# **EL PASO COUNTY PLANNING AND COMMUNITY DEVELOPMENT DEPARTMENT**

## **STORMWATER MANAGEMENT PLAN CHECKLIST**

Revised: July 2019

SHEET 2 OF 3

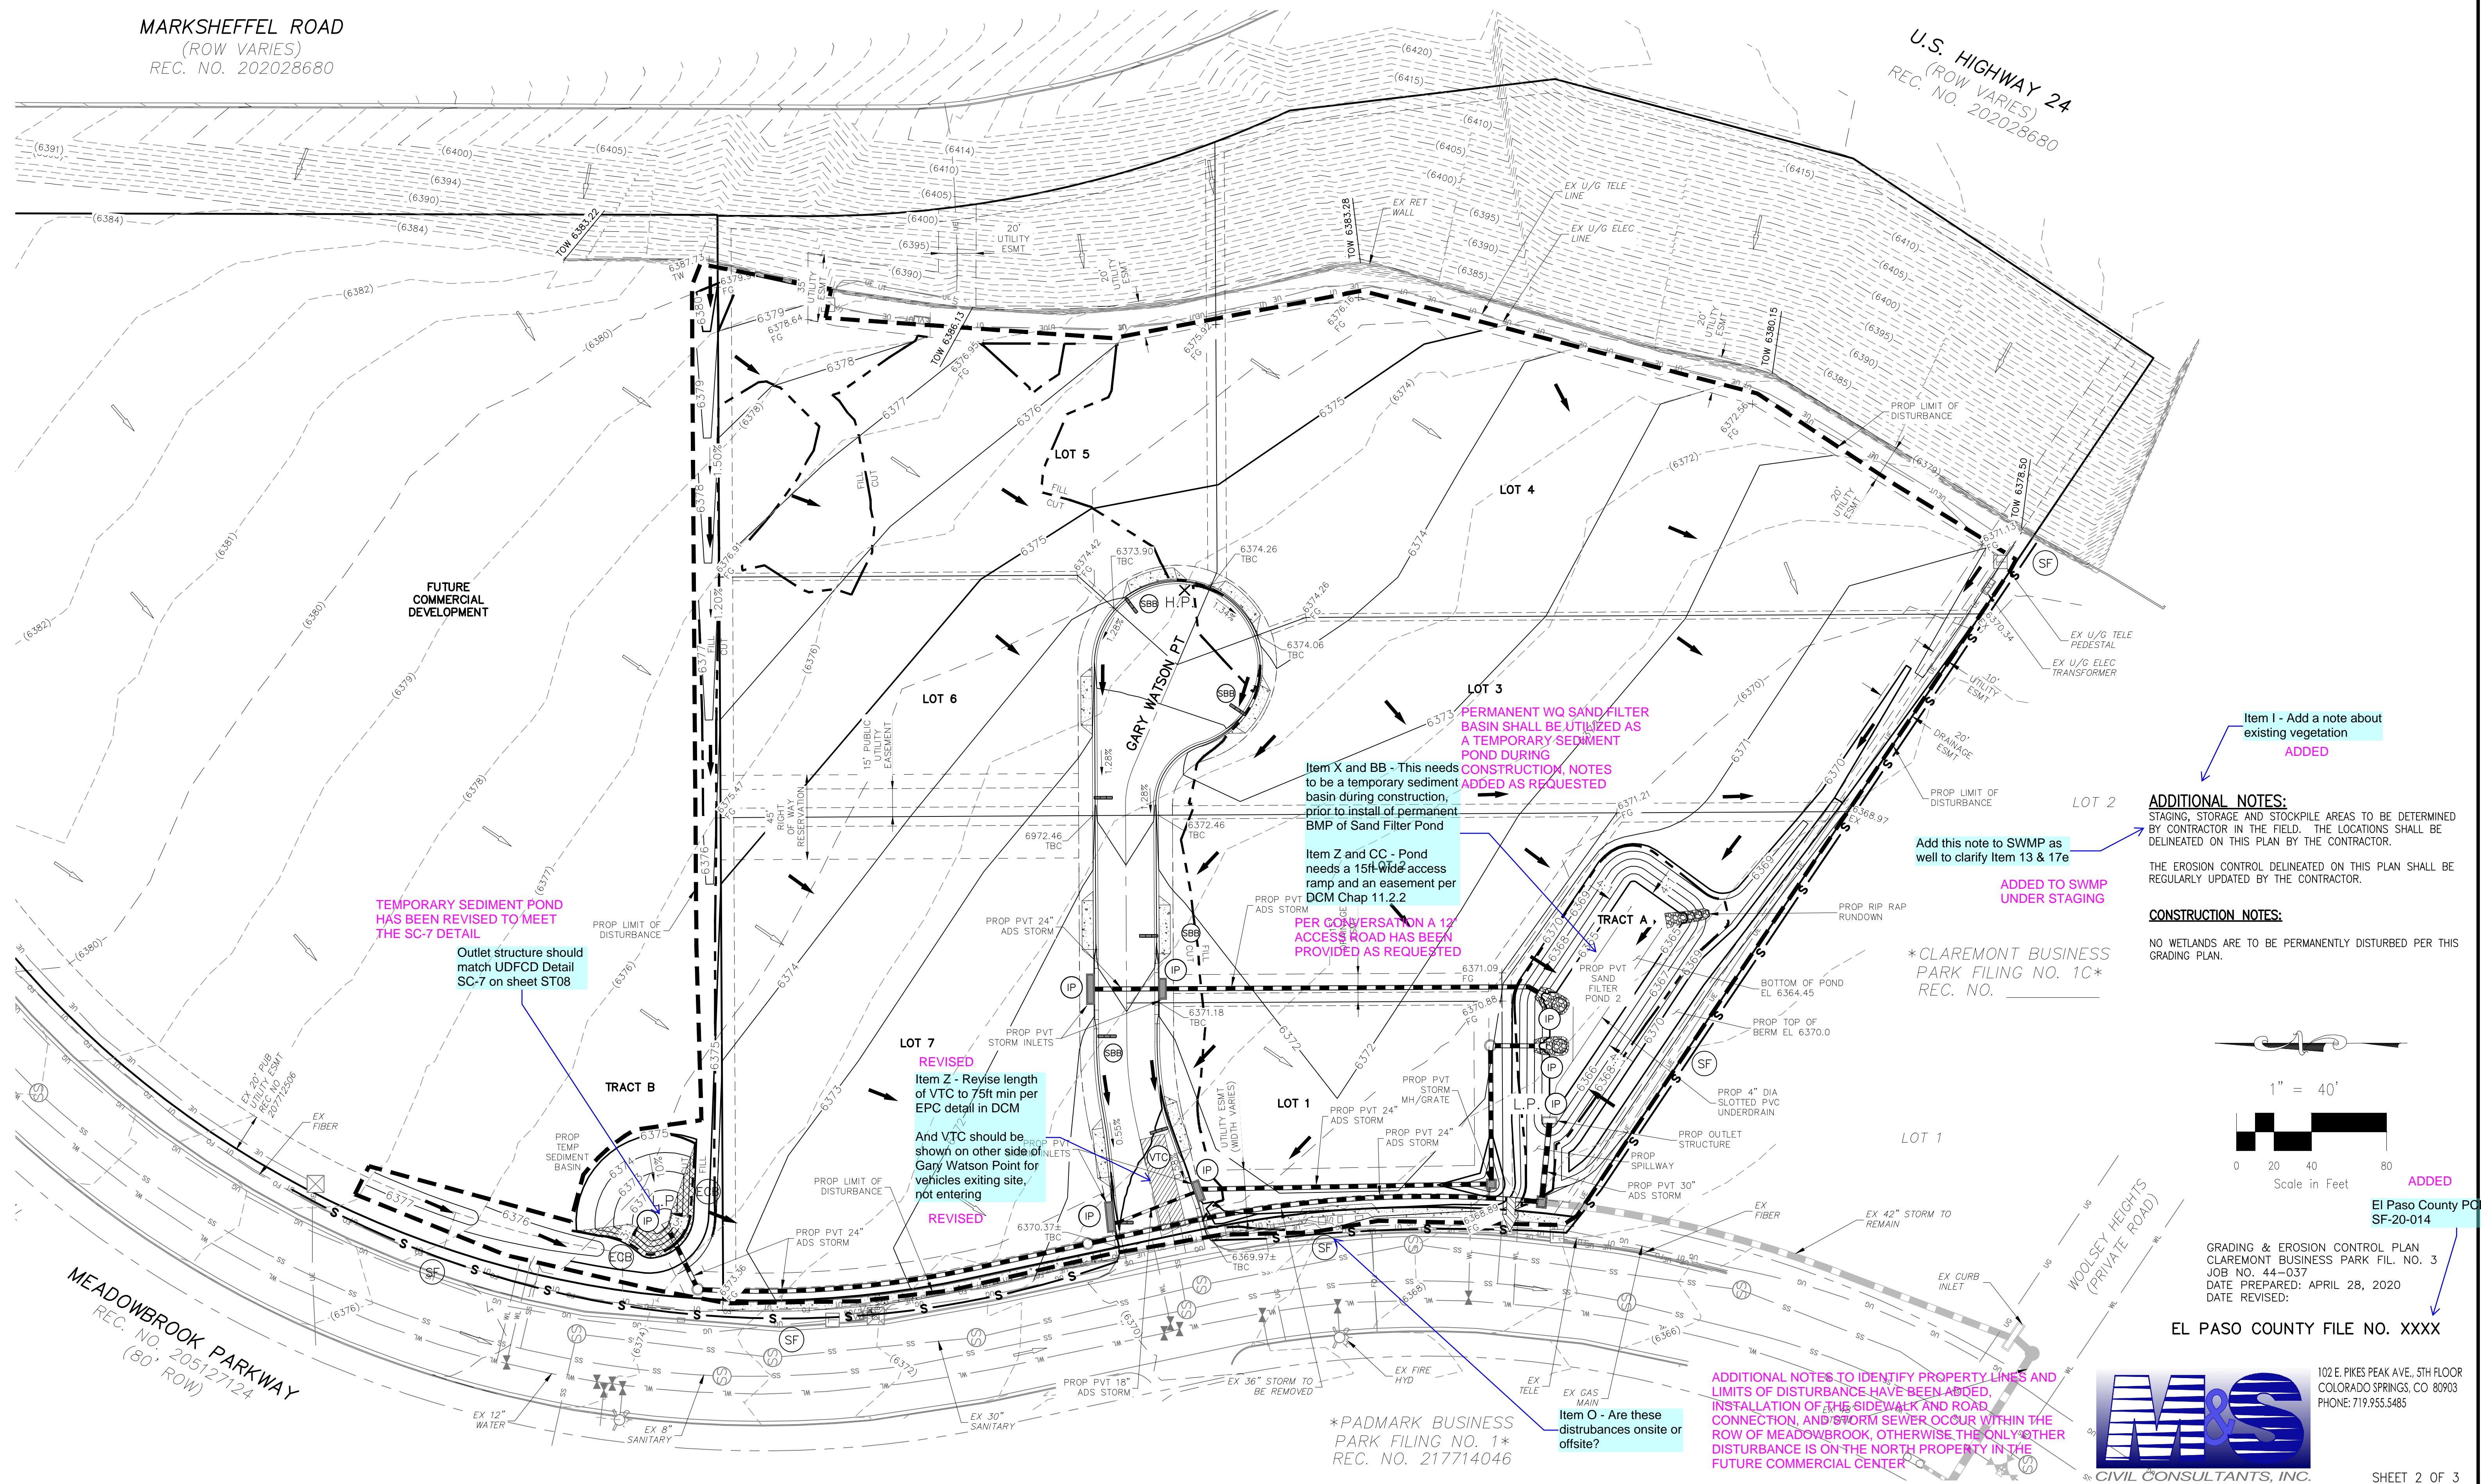
Revised: July 2019		Applicant	PCD
17	SWMP Map to include:		
17a	construction site boundaries See comments on GEC Plan - Sheet 1 of 3	X	X
17b	flow arrows to depict stormwater flow directions	X	✓
17c	all areas of disturbance	X	✓
17d	areas of cut and fill	X	✓
17e	areas used for storage of building materials, soils (stockpiles) or wastes	X	✓
17f	location of any dedicated asphalt / concrete batch plants	N/A	✓
17g	location of all structural control measures See comments on GEC Plan - Sheet 1 of 3	X	X
17h	location of all non-structural control measures See comments on GEC Plan - Sheet 1 of 3	X	X
17i	springs, streams, wetlands and other surface waters, including areas that require maintenance of pre-existing vegetation within 50 feet of a receiving water	N/A	✓
18	Narrative description of all structural control measures to be used. Modifications to EPC standard control measures must meet or exceed County-approved details.	X	✓
